FIVE ESTUARIES OFFSHORE WIND FARM

10.19 APPLICANT'S COMMENTS ON DEADLINE 1 SUBMISSIONS

Application Reference:	EN010115
Document Number:	10.19
Revision:	A
Pursuant to:	Deadline 2
Eco-Doc Number:	005416679-01
Date:	22 October 2024

SLR Cable drum vehicle
 Overall Length **25.660m**
 Overall Width **3.000m**
 Overall Body Height **4.900m**
 Min Body Ground Clearance **0.427m**
 Max Track Width **3.000m**
 Lock to lock time **6.00s**
 Wall to Wall Turning Radius **9.800m**

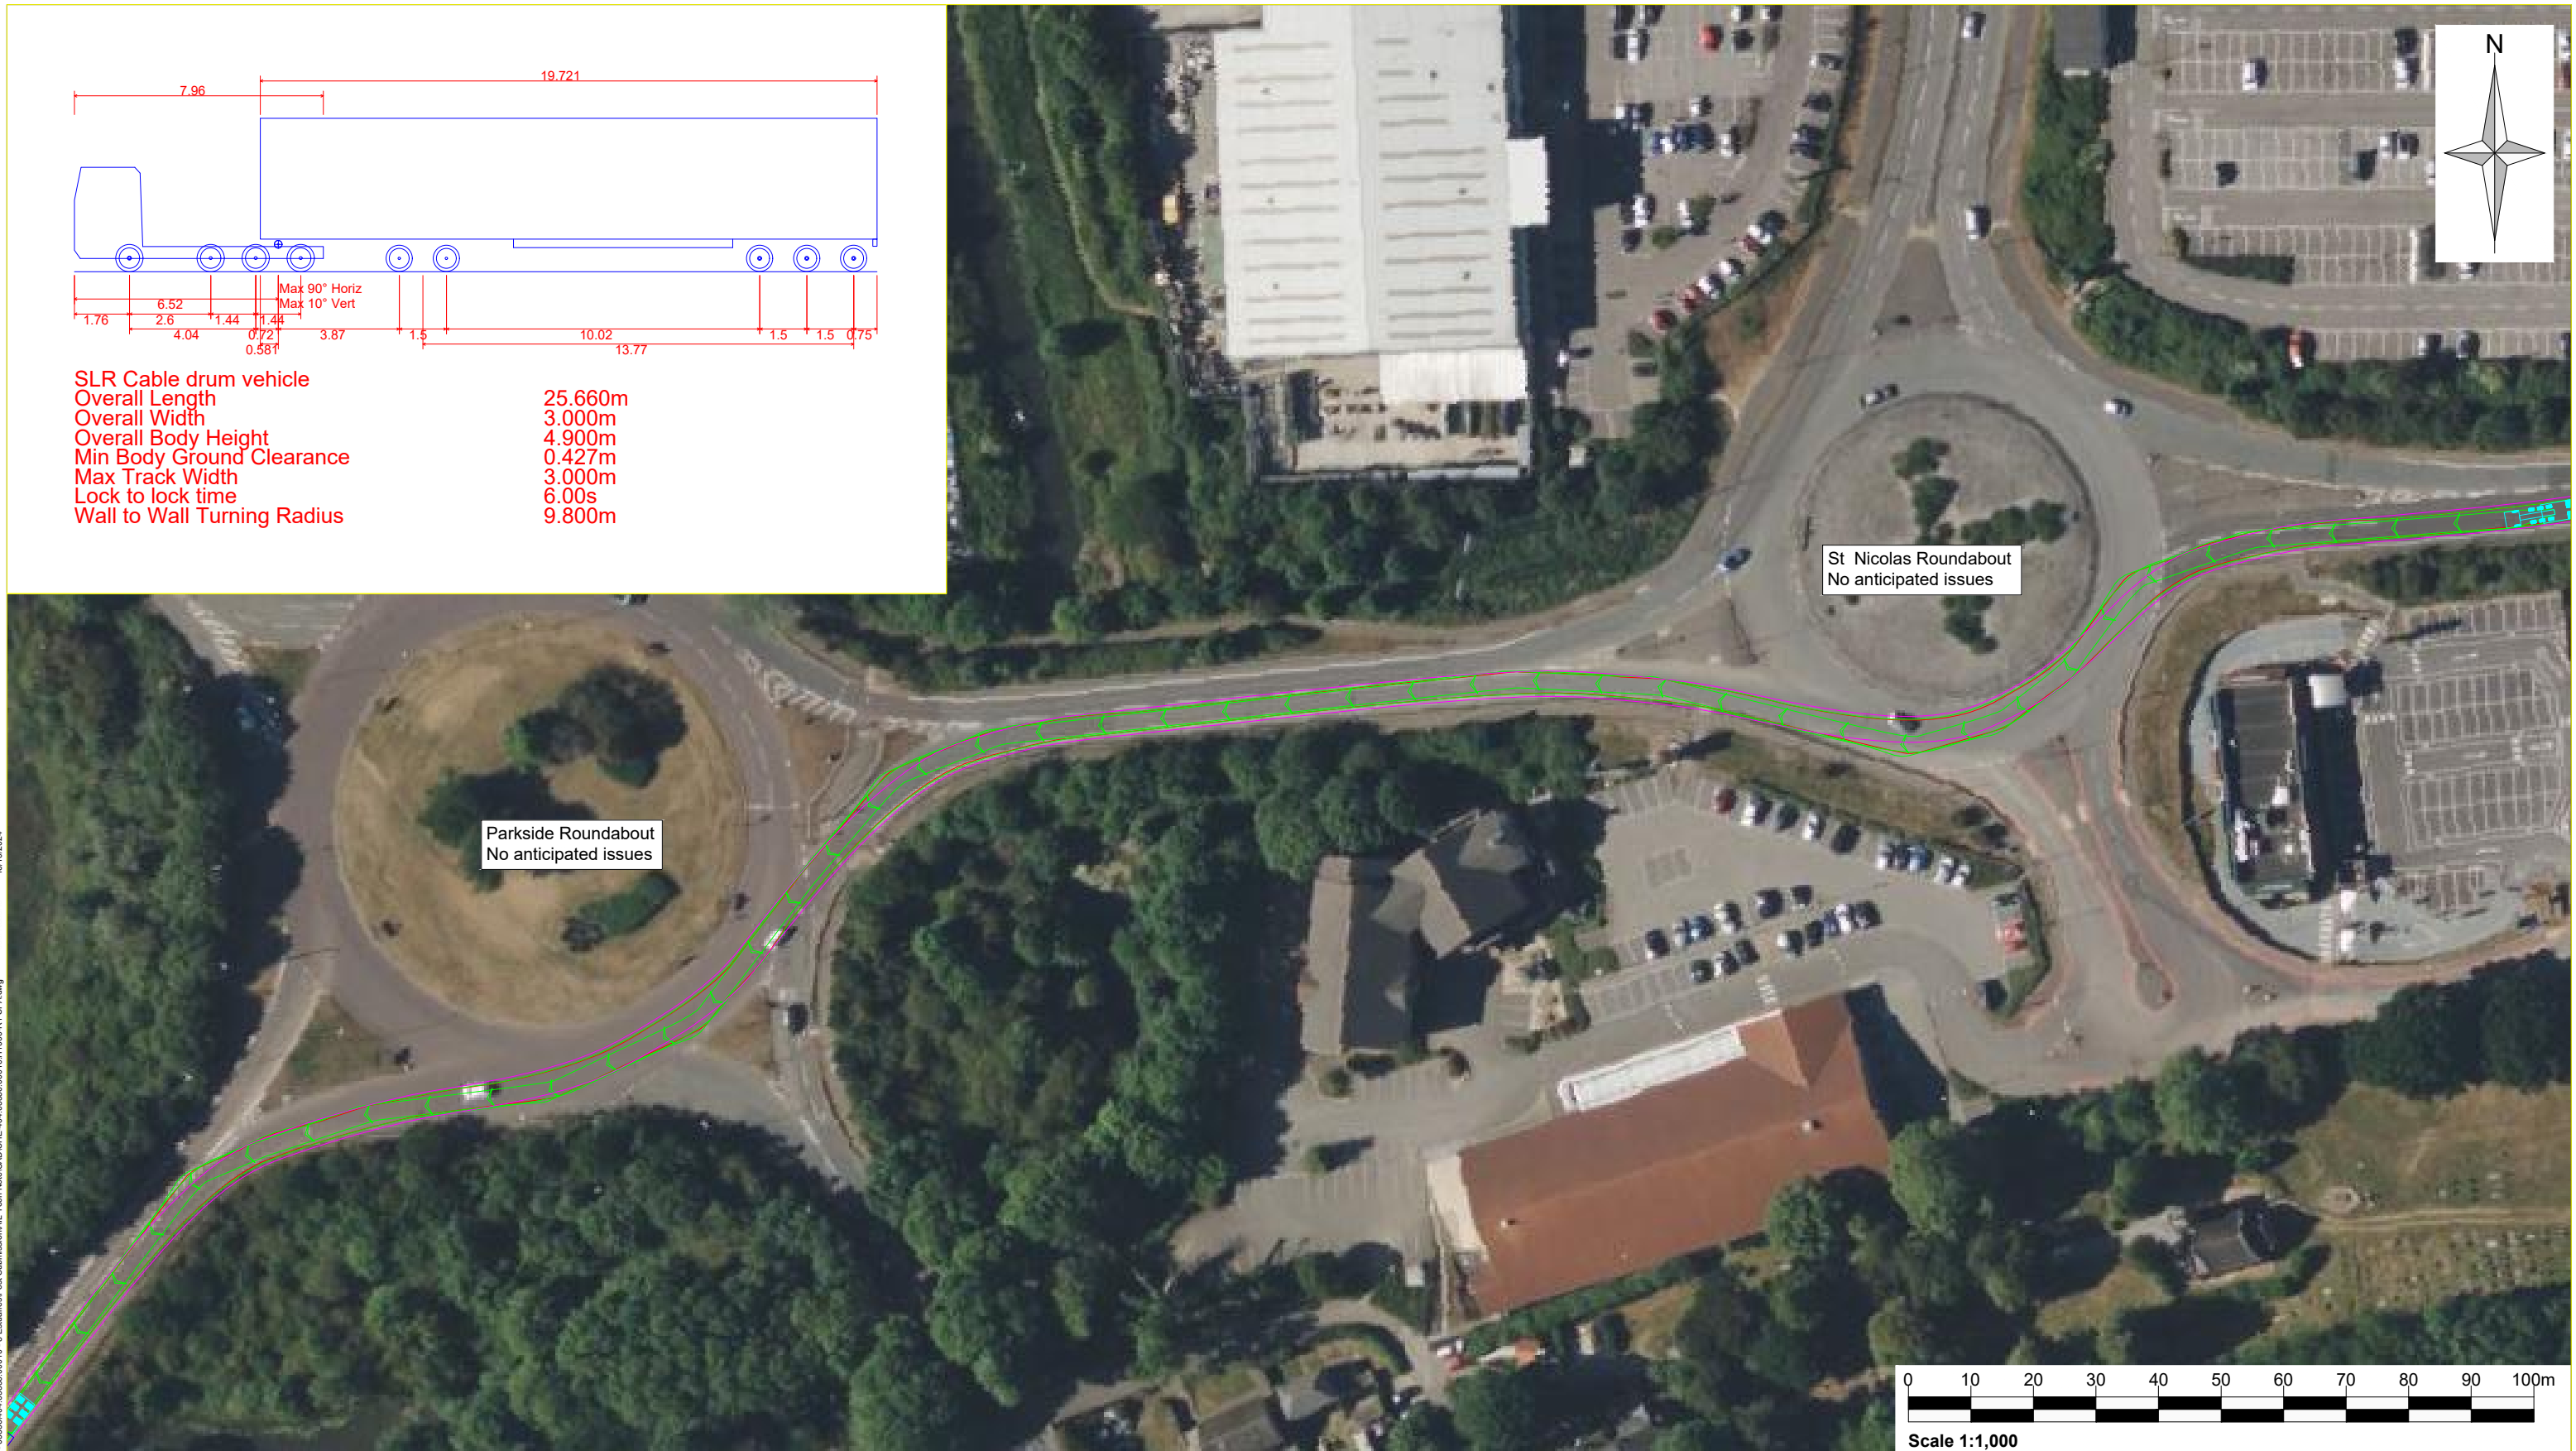
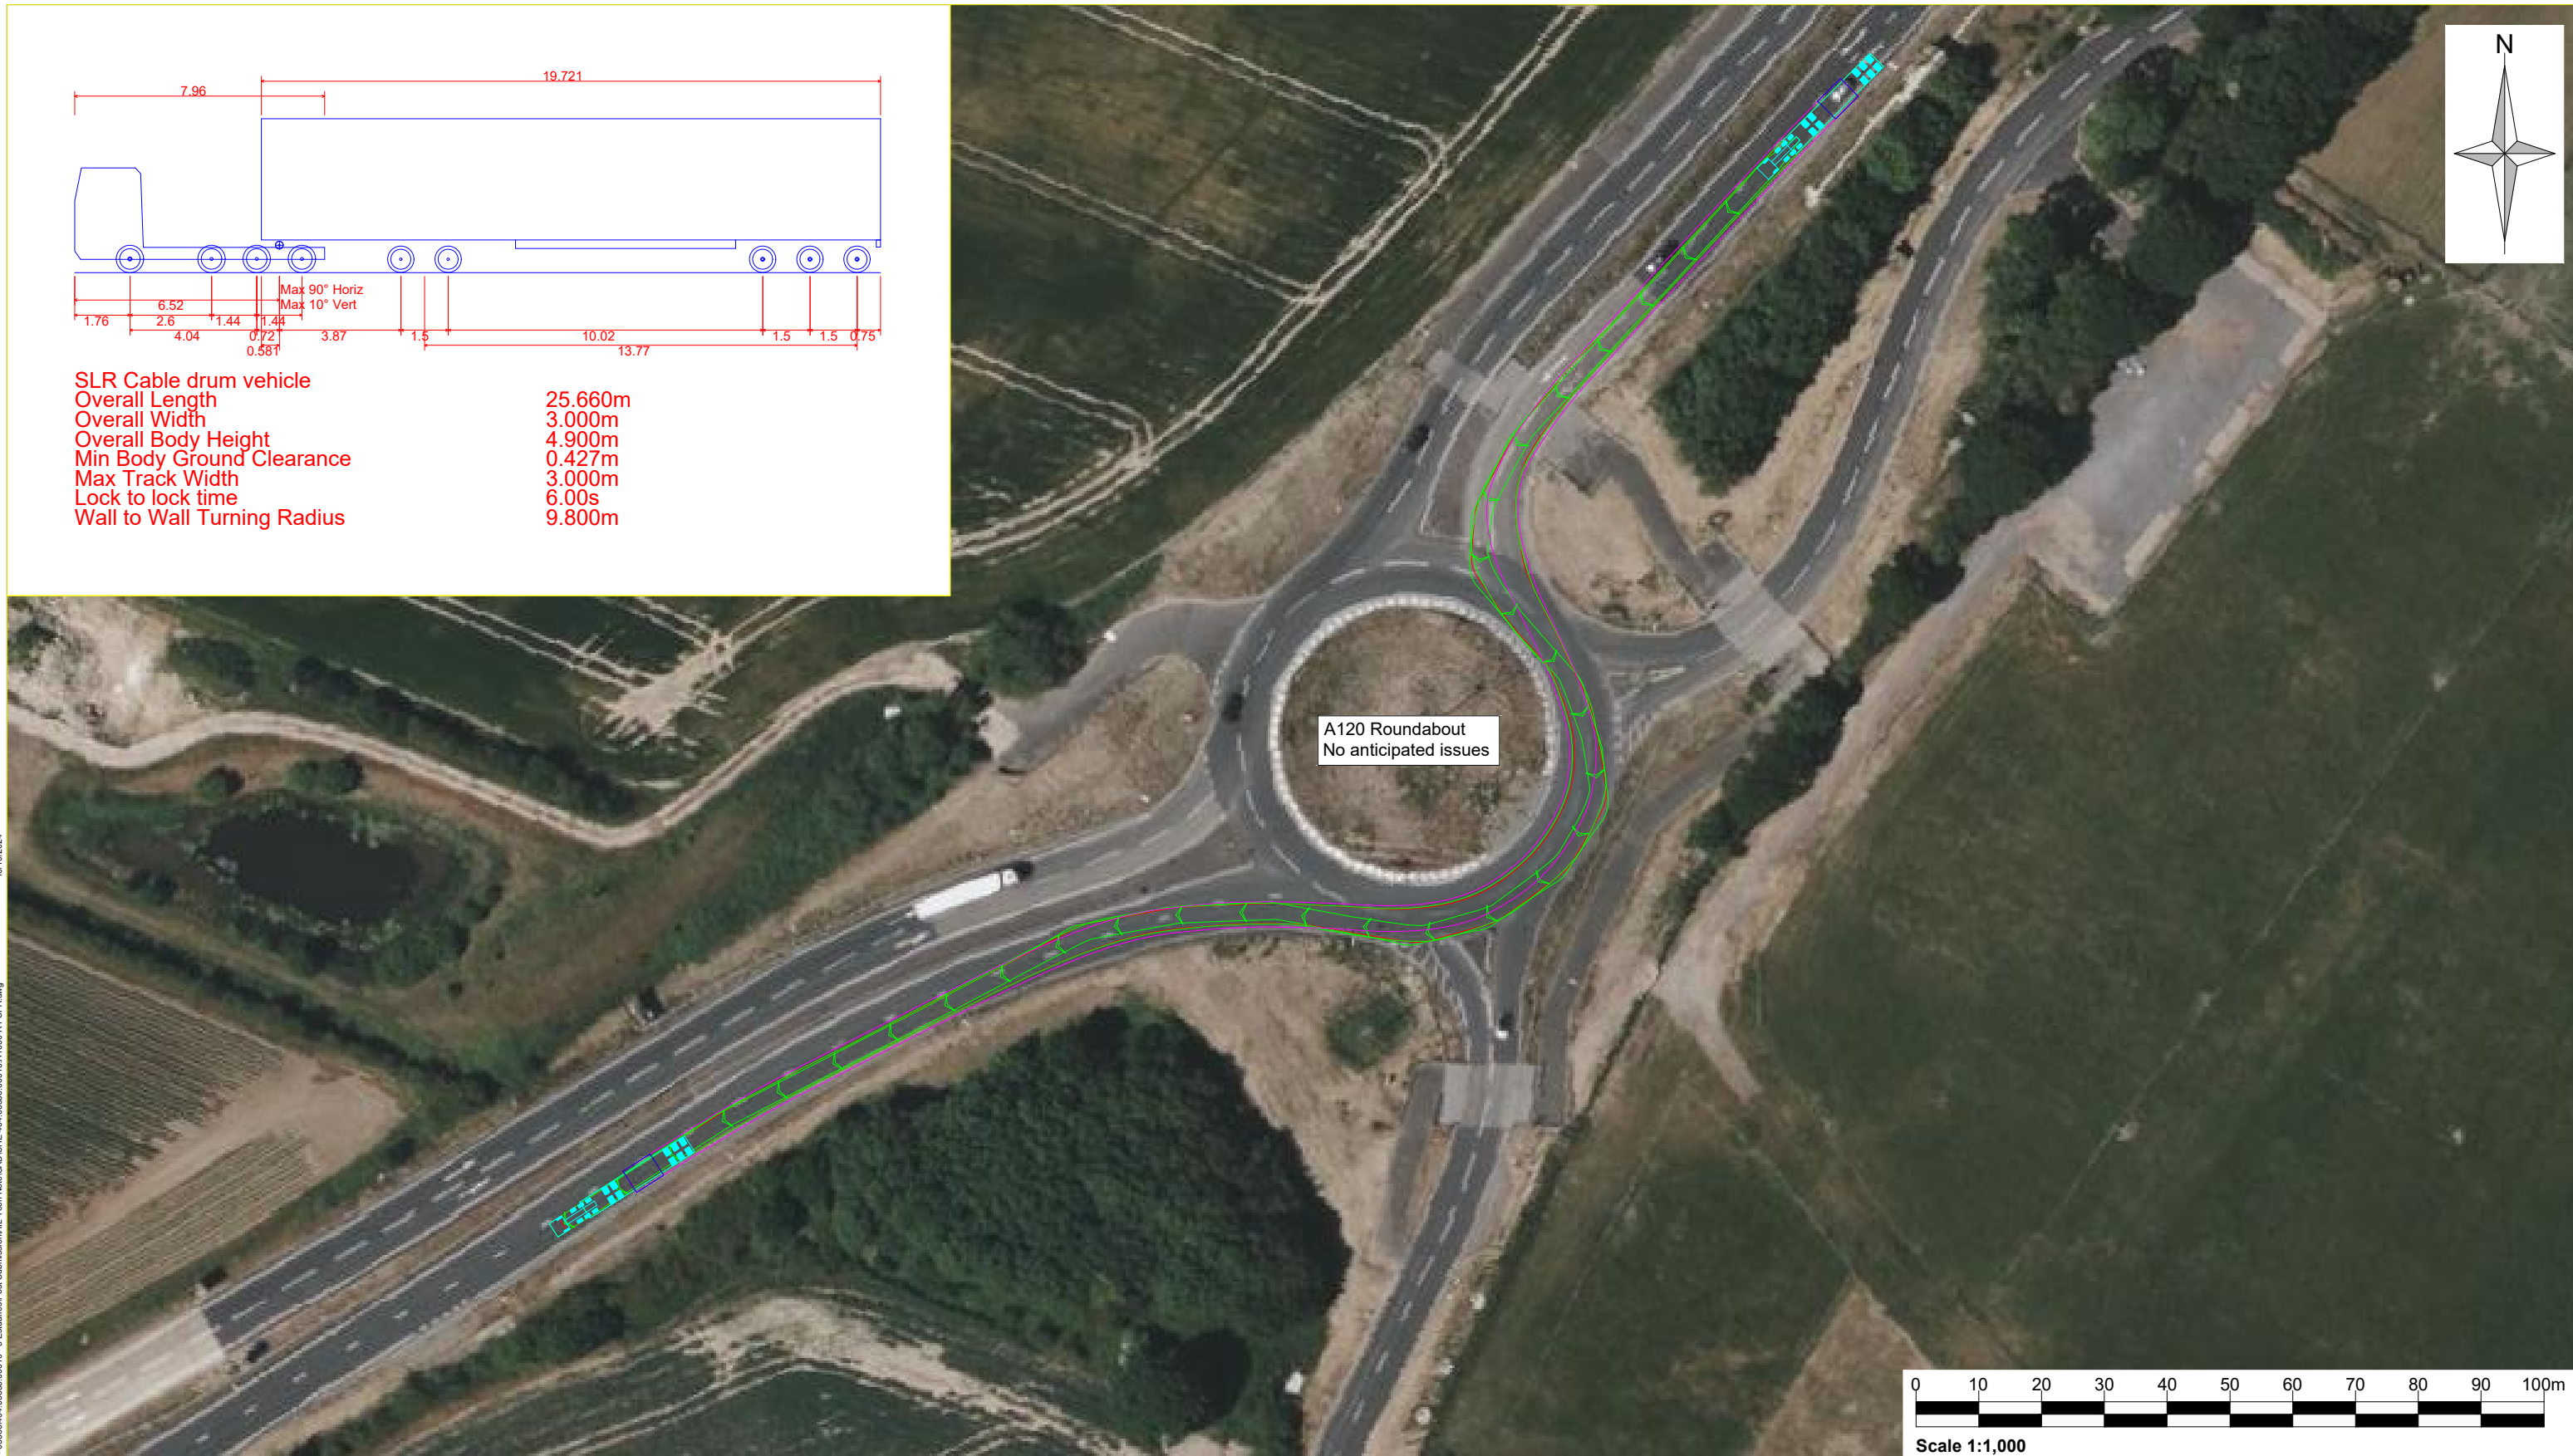
<p>AILs</p> <p>There is no reference to cable drum AILs within the Traffic and Transport chapter [APP-090], but it became clear at ISH1 that there is a requirement for these to access the proposed accesses on the rural road network. There are concerns around the routes for AILs for these cable drums associated with all of the accesses on the route, particularly the number and frequency. Clarity is sought on what assessment has been undertaken of the routes, including whether a structural assessment has been undertaken to ensure the deliverability of their routes i.e. can the local road</p>	<p>The Applicant has prepared an Abnormal Indivisible Load (AIL) Technical Note, which is being submitted at Deadline 2. This includes swept path analyses of the largest likely cable drum delivery vehicle on the highway network.</p> <p>There would be an estimate of 280 to 290 cable drum vehicle movements, which are included in the forecast construction vehicle movements set out in the Traffic and Transport chapter [REP1-018].</p>

network accommodate these movements. If an assessment has not been undertaken of the routes, it may be that they are not deliverable, and so would have to use alternative routes with different impacts. This presents a risk to the project. We would request that swept path drawings are provided at key junctions along these routes, and structures pinpointed along the designated routes with assessments undertaken of those structures.
